Our Ref: R/197/18/HH
Your Ref:

Town & Country Planning Act 1990 (as amended)
Town & country Planning (Development Management Procedure) (England) Order 2015
Application for Planning Permission for Works or Extension to a Dwelling

Development Rear ground & first floor extension & front first floor gable extension.
Location 1 Pigeonhouse Lane Rustington

Drawing Title: PROPOSED BLOCK PLAN

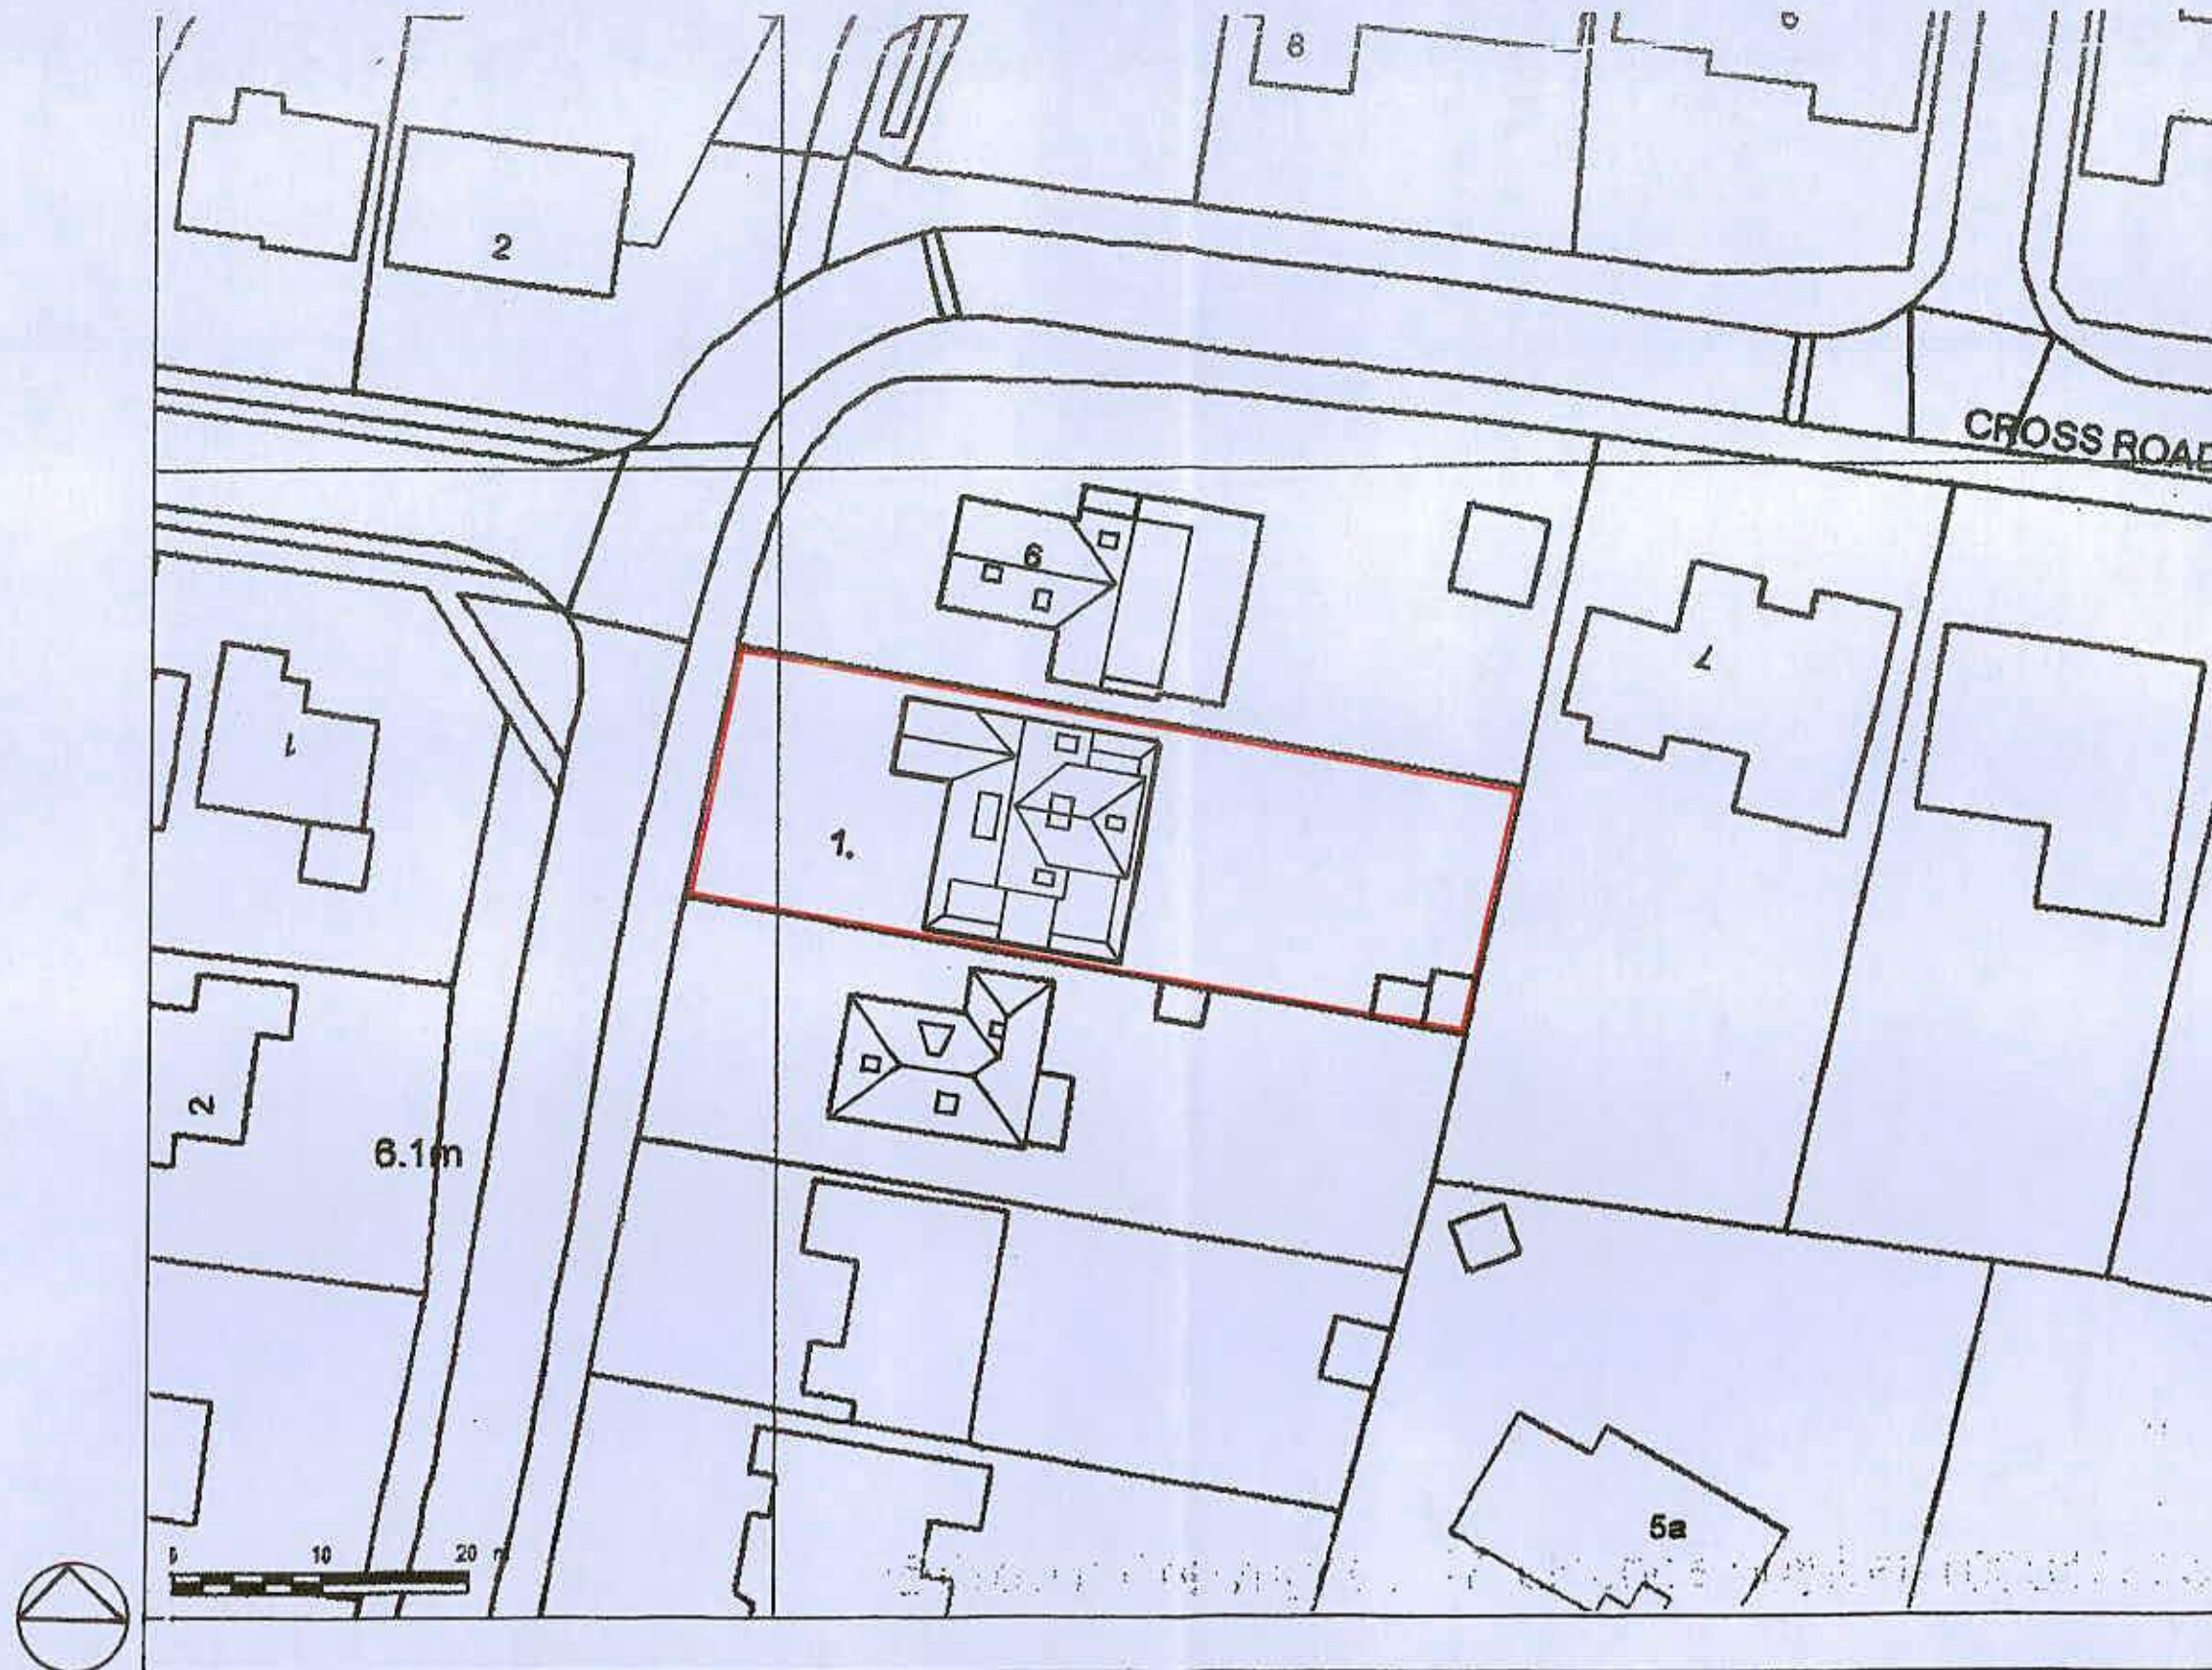
Block Plan

Please submit 1 electronic or 3 paper copies of an amended block/site plan at a scale of 1:500 or 1:200 clearly showing the position of the proposed works together with measurements to the boundaries.
